**WEST SUSSEX COUNTY COUNCIL
PLANNING SERVICES CONSULTATION**

SUBJECT: BR/340/17/DOC - Application for approval of details reserved by condition imposed under planning permission BR/108/16/PL relating to condition No. 3 (Schedule of materials & finishes to be used for the external walls & roofs of the proposed extensions/alterations) & condition No. 5 (covered & secure cycle parking spaces).

19, High Street, Bognor Regis, West Sussex, PO21 1RJ

GROUND FLOOR 1:50 @ A1

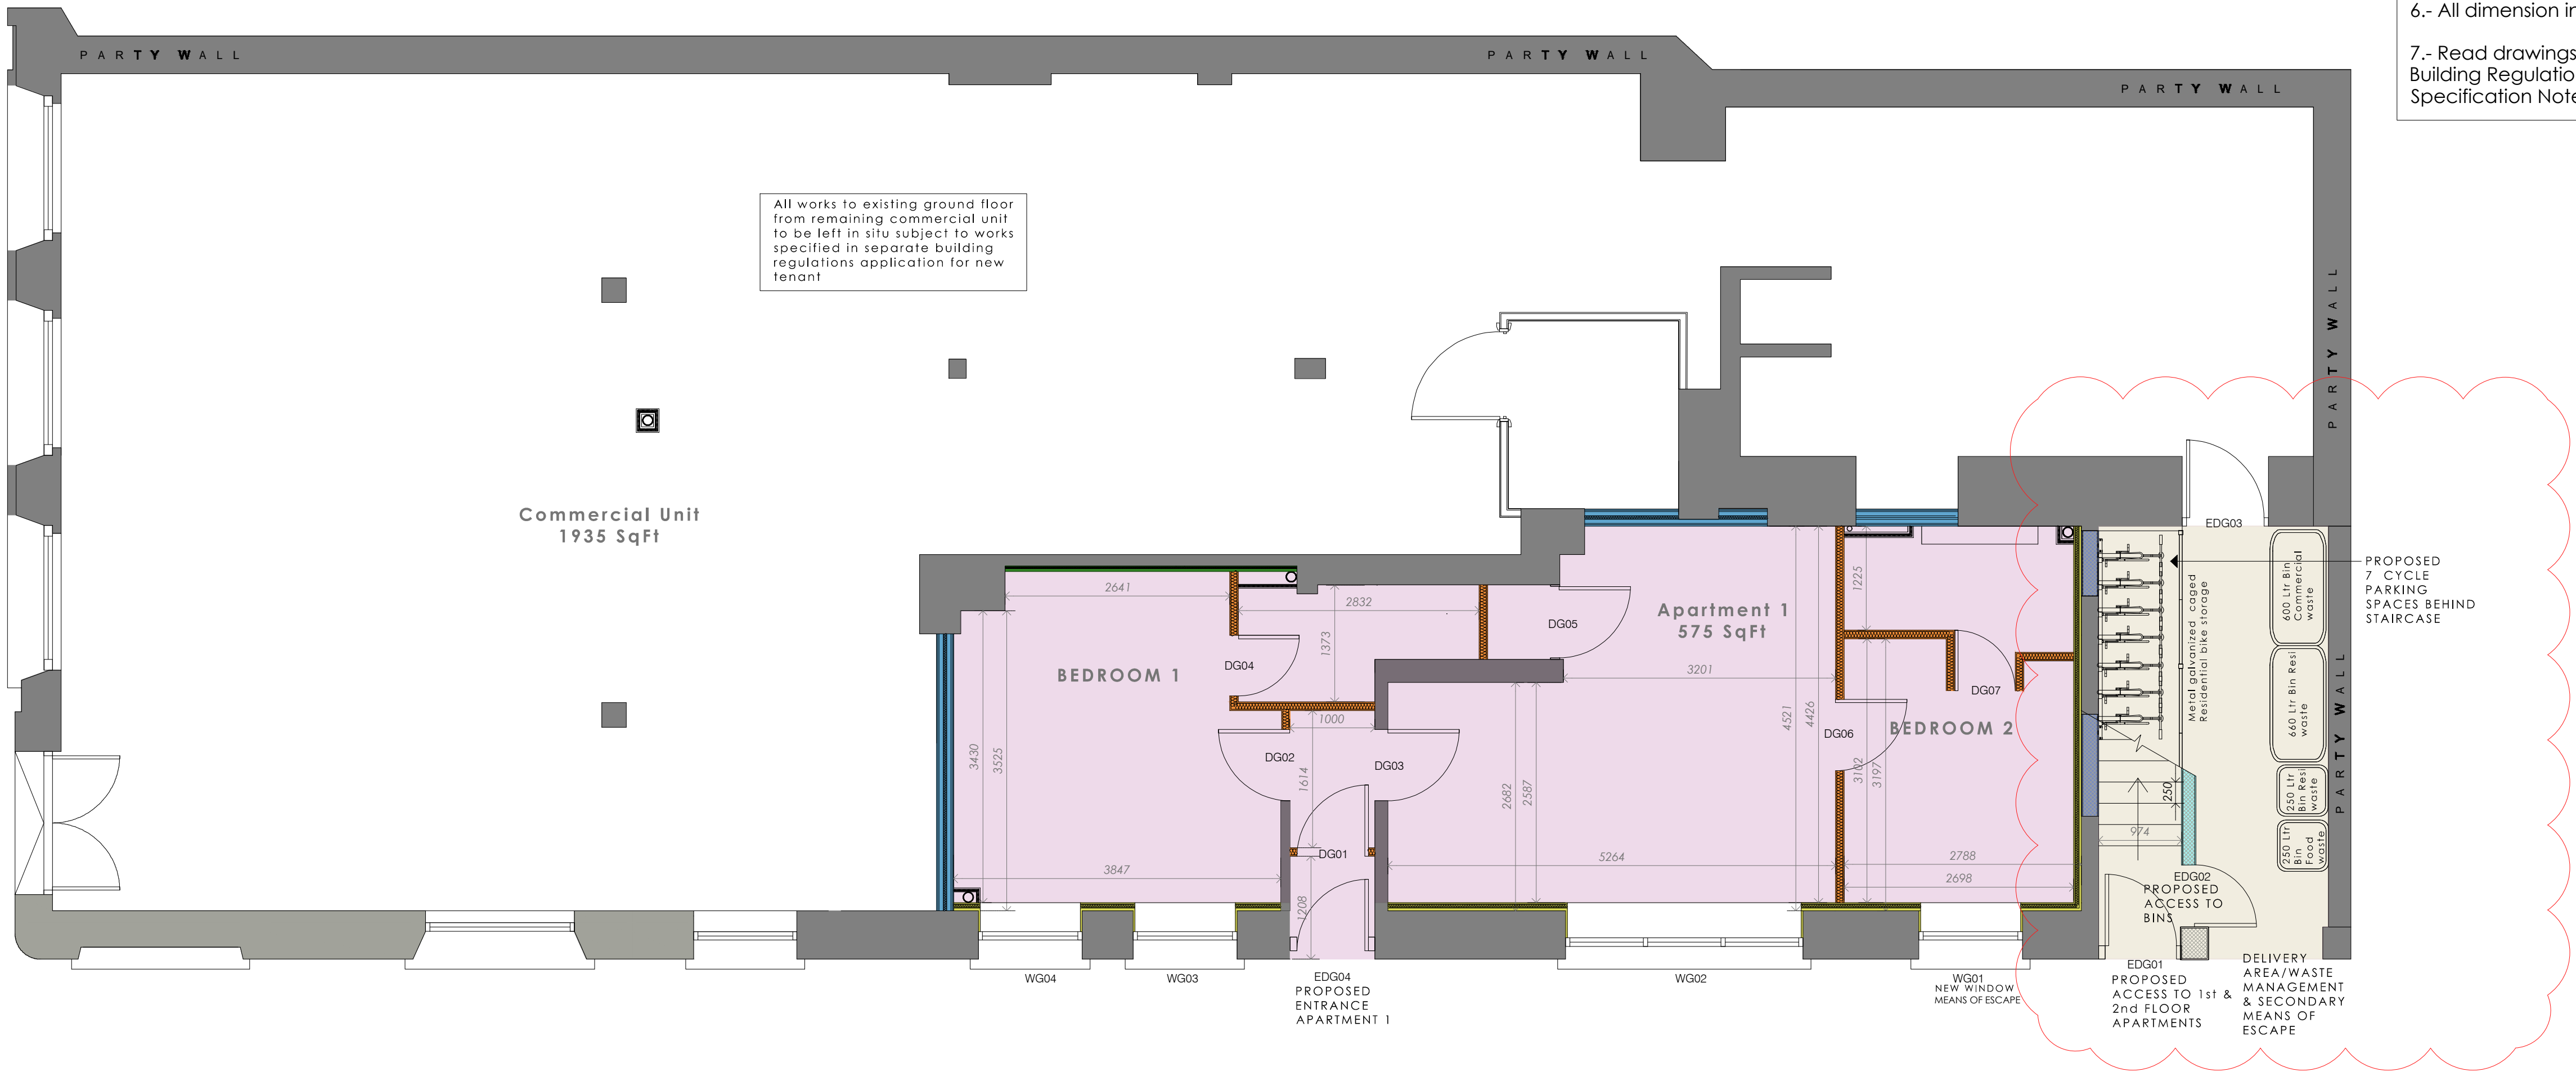
Secure and covered cycle storage has been provided within the associated communal metal galvanized residential bike storage cages which are solely for use of the flats. The provision meets the requirement for a scheme of this size.

The LHA are satisfied that this condition can be discharged.
